## Wicklow County Council

RE: Referral Ref. ABP 320327-24

I refer to your letter of the 06/08/24 in relation to the above mentioned Referral. The Planning Authority considers that its reasons and considerations in relation to the submitted S5 Declaration Request are fully set out in its planning report and Declaration previously forwarded to the Board. However, the Planning Authority would like, in the interests of clarification, to comment on the submitted Referral as follows.

CLIENT	Tondo Ltd.				DATE	19-10-2022
JOB TITLE	Development at Kippure Estate					
LOCATION	Manor Kilbride, Blessington, Co. Wicklow					
STATUS	Pre-Planning		CHECKED	AB	SCALE	1:100@A1
DRAWN	NF		APPROVED	AB		
DRAWING No.		DRAWING TITLE			REVISION	
PL-0206-01-KE		Structure 02 and Structure 06			D

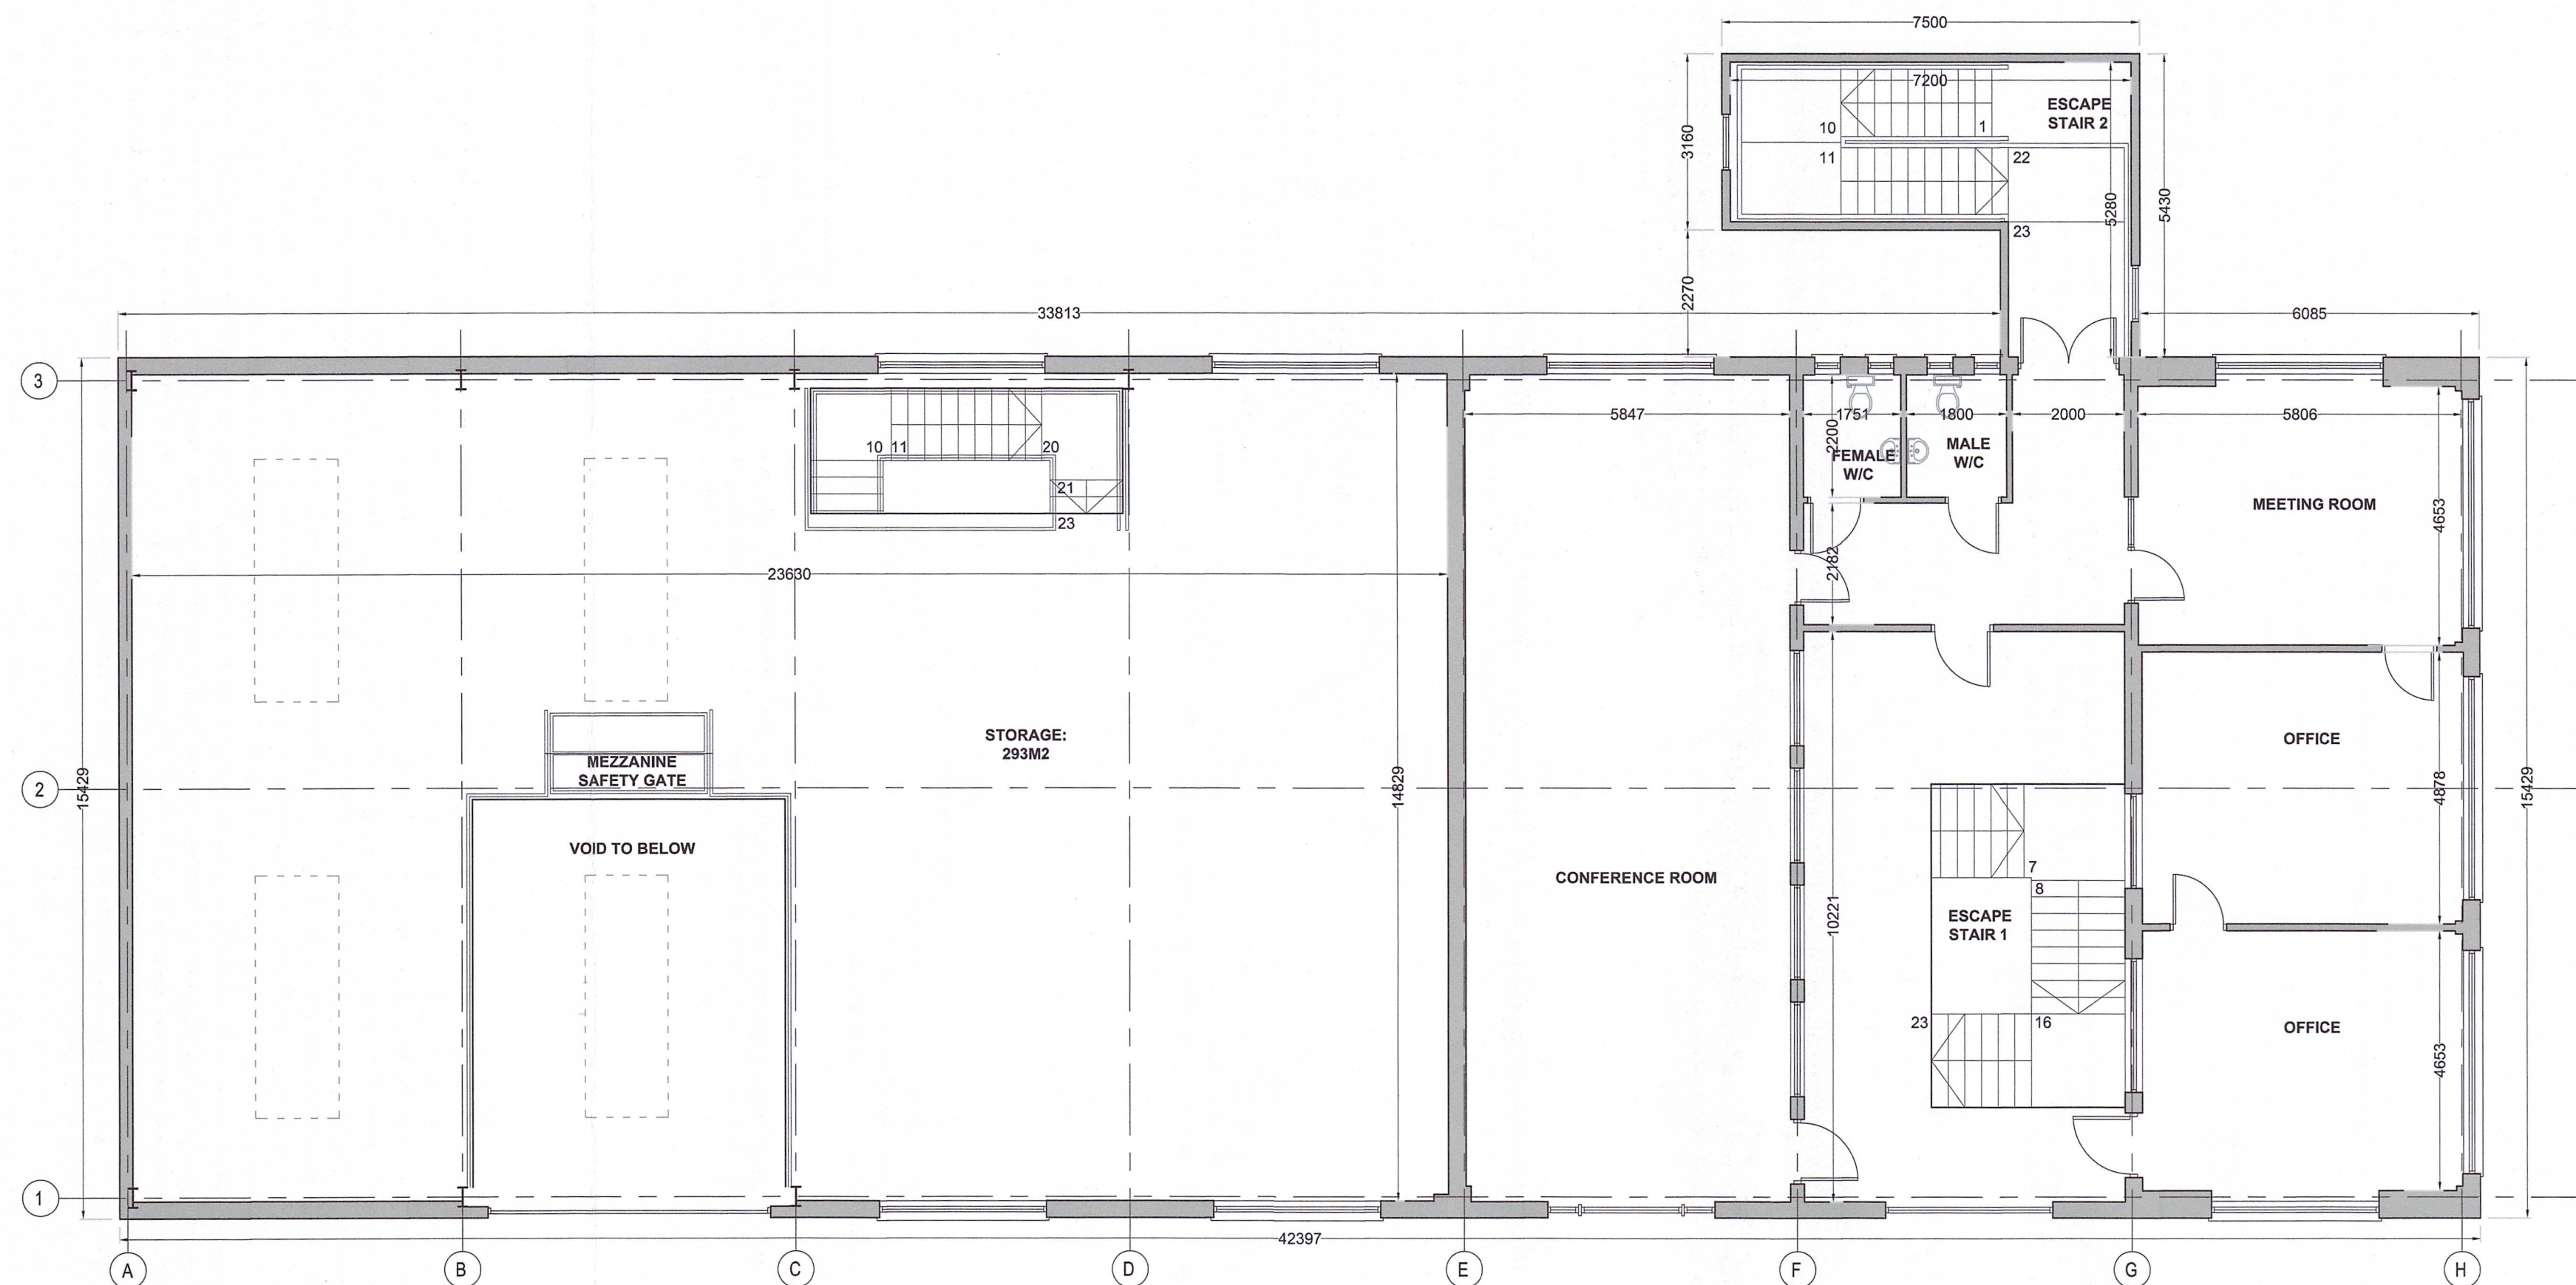
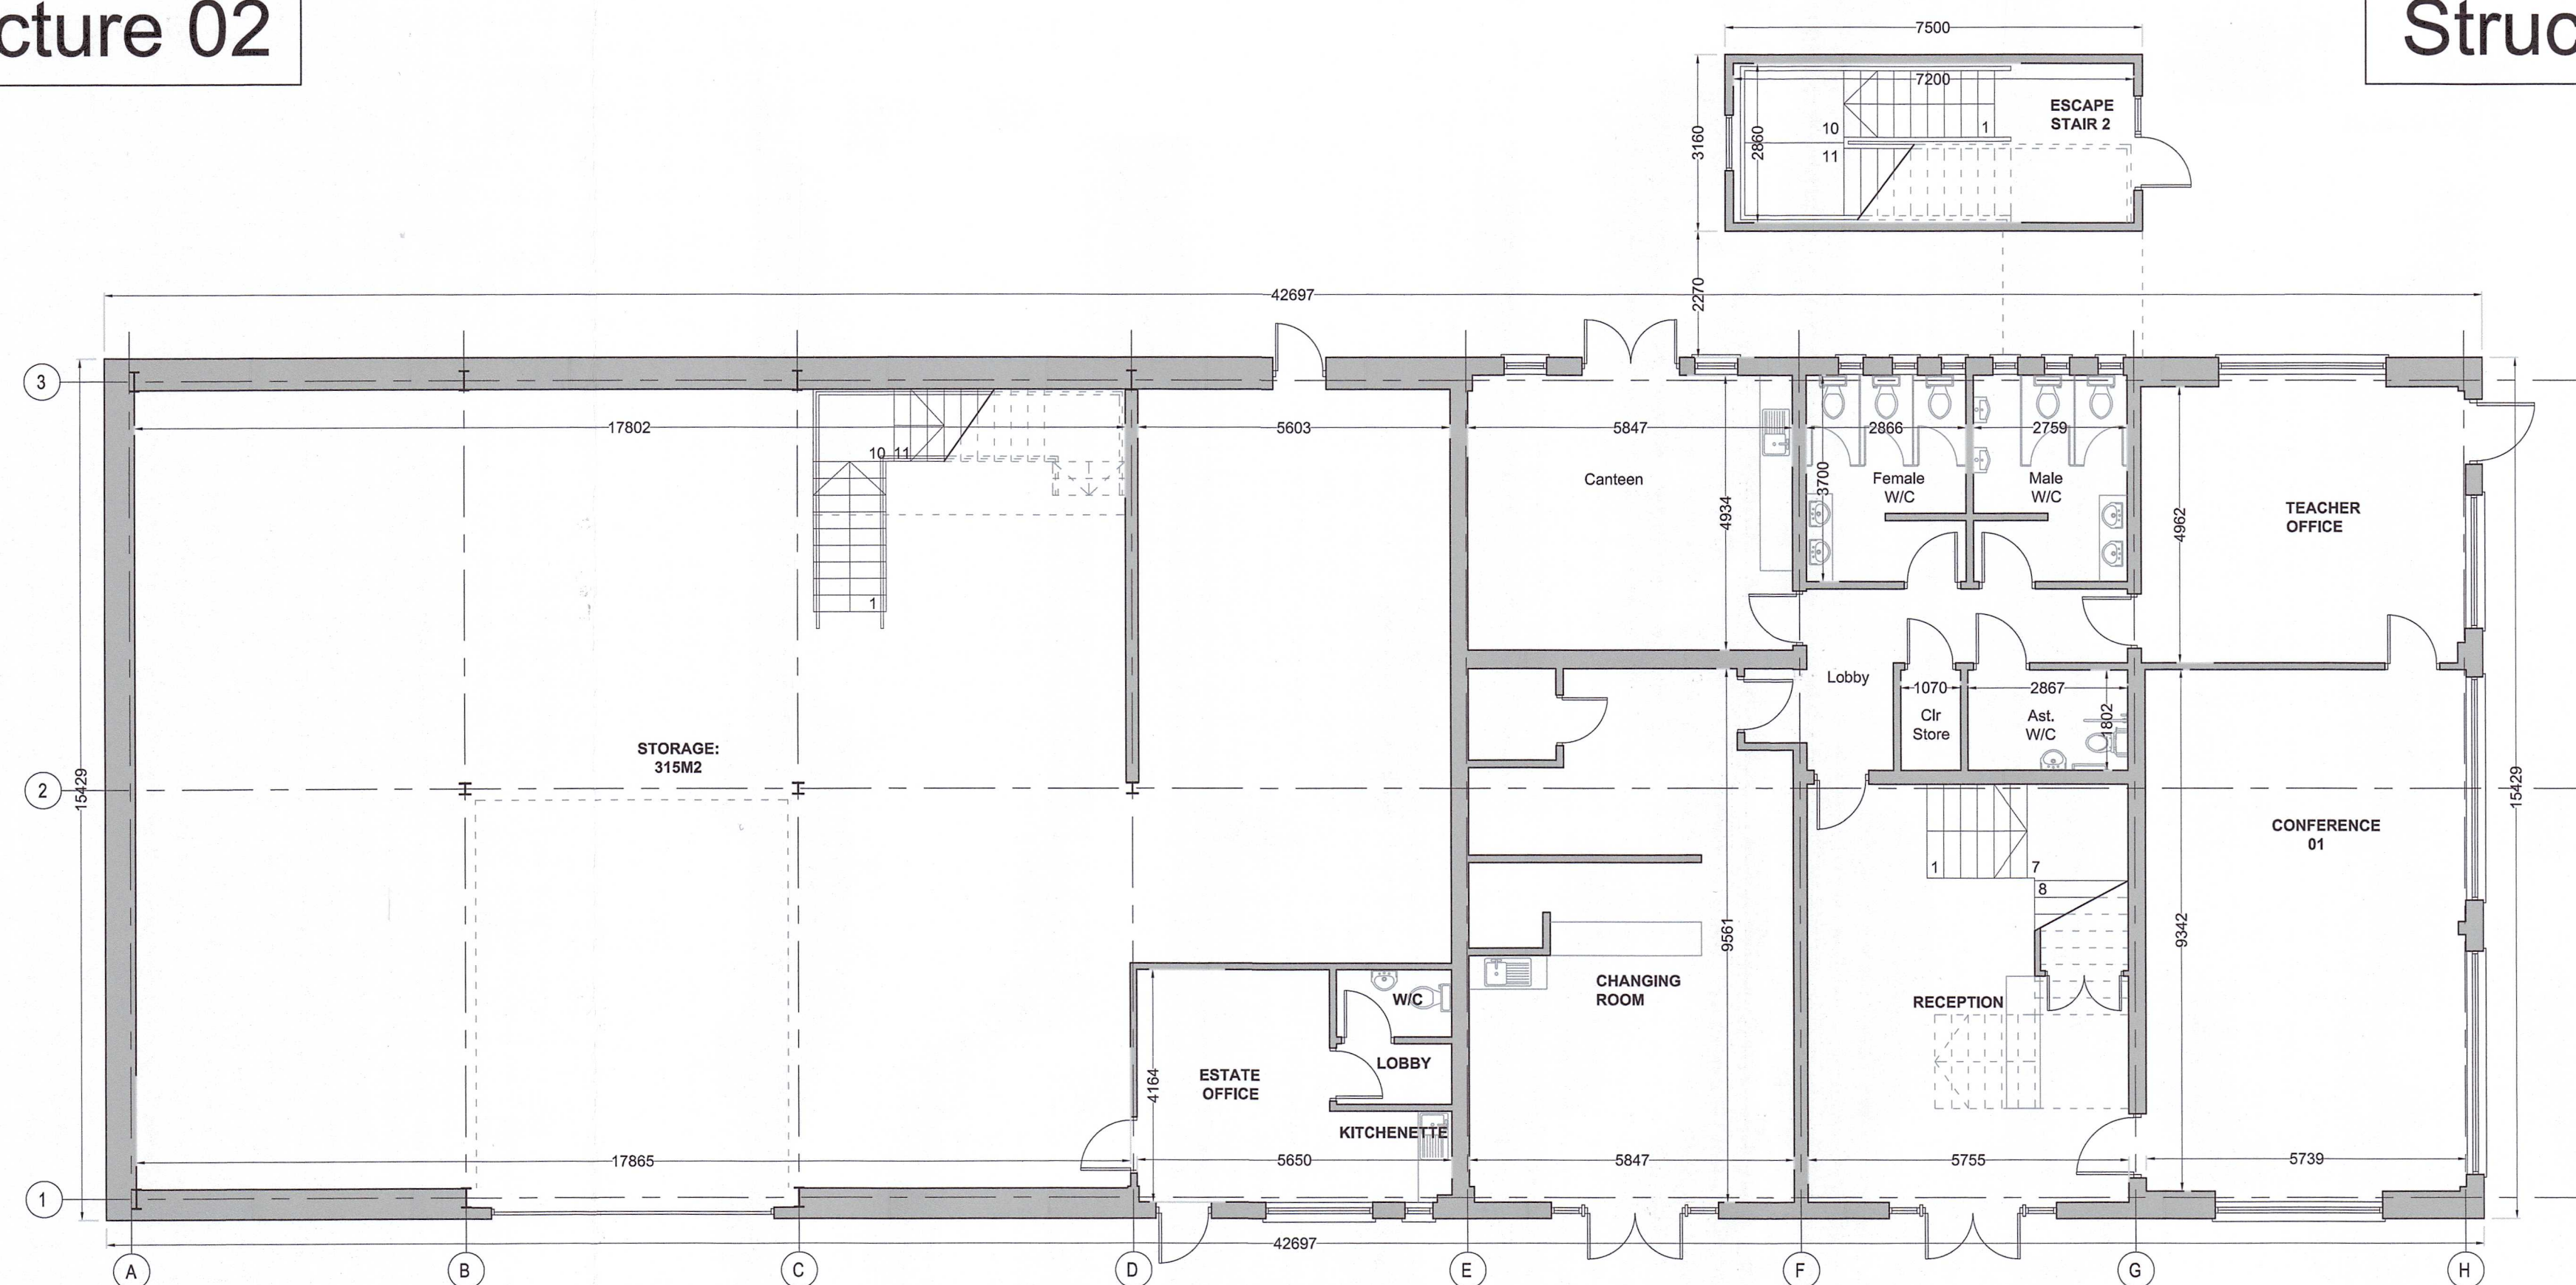
Where materials are stored in an Agricultural Structure, just because they are materials that can be used for Agricultural purposes, does not automatically mean that the requirement in Conditions and Limitations No. 1 for Class 9 re use for agriculture or forestry has been met. What those materials are being used for is of relevance and hence if such materials are being used for development other than agriculture or forestry then Conditions and Limitations No. 1 would not be complied with.

The aggregation of the floor areas for the various structures the Referrer is claiming exemptions for under Class 9 is legitimate, as the Referral as a whole has to be assessed. It is noted that the assessment of aggregate floor areas is included for the purposes of completeness, so that all relevant Conditions & Limitations of Class 9 are assessed.

Given the definition of gross floor area as defined in Article 3 of the Regulations, it is considered that the inclusion of Mezzanine areas in the calculations of the sizing of such structures is appropriate and therefore the building does exceed 300sqm.

The Board may also wish to address the use of this structure, given the Referrer raises the use of the structure. It is noted the exemption under Class 9 includes a Condition & Limitation in relation to the use being only for agriculture or forestry.

It is noted that no evidence is provided to support the original agricultural use of the structure.

From the definition of gross floor area as defined in Article 3 of the Regulations it is considered the inclusion of upper floor areas in the calculations of the sizing of such structures is appropriate.

CLIENT	Tondo Ltd.			DATE	19-10-2022
JOB TITLE	Development at Kippure Estate				
LOCATION	Manor Kilbride, Blessington, Co. Wicklow				
STATUS	Pre-Planning	CHECKED	AB	SCALE	1:100@A1
DRAWN	NF	APPROVED	AB		
DRAWING No.	PL-03-01-KE	DRAWING TITLE	Structure 03	REVISION

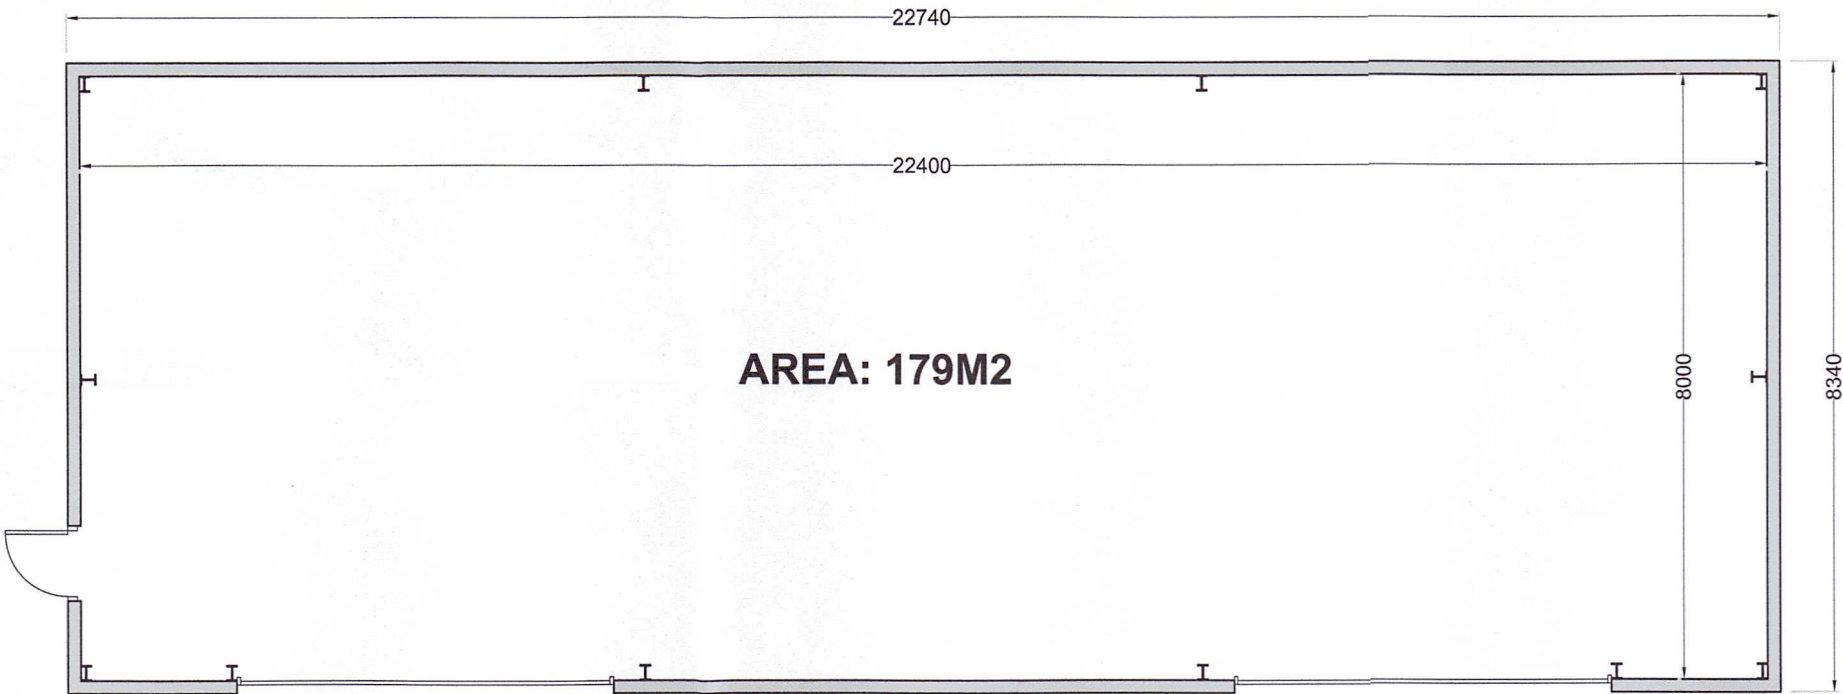
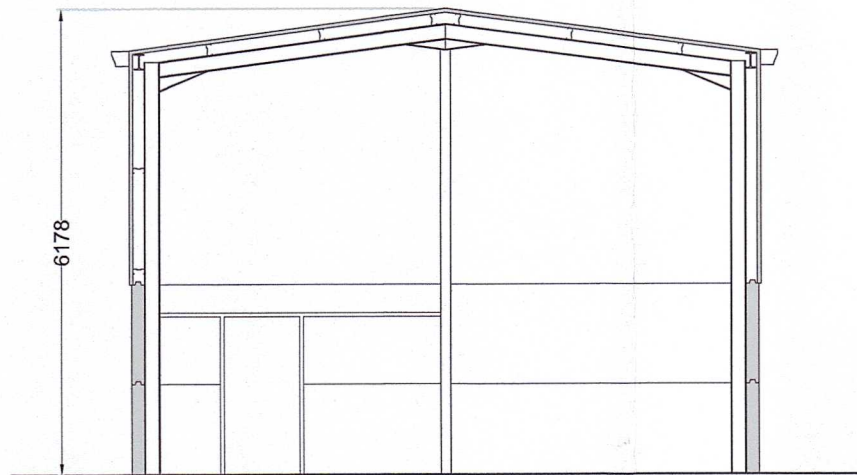
It is noted in the Planning Authority's report that the use of the structure for agricultural use was not demonstrated.

The comments under the above headings re aggregation are relevant.
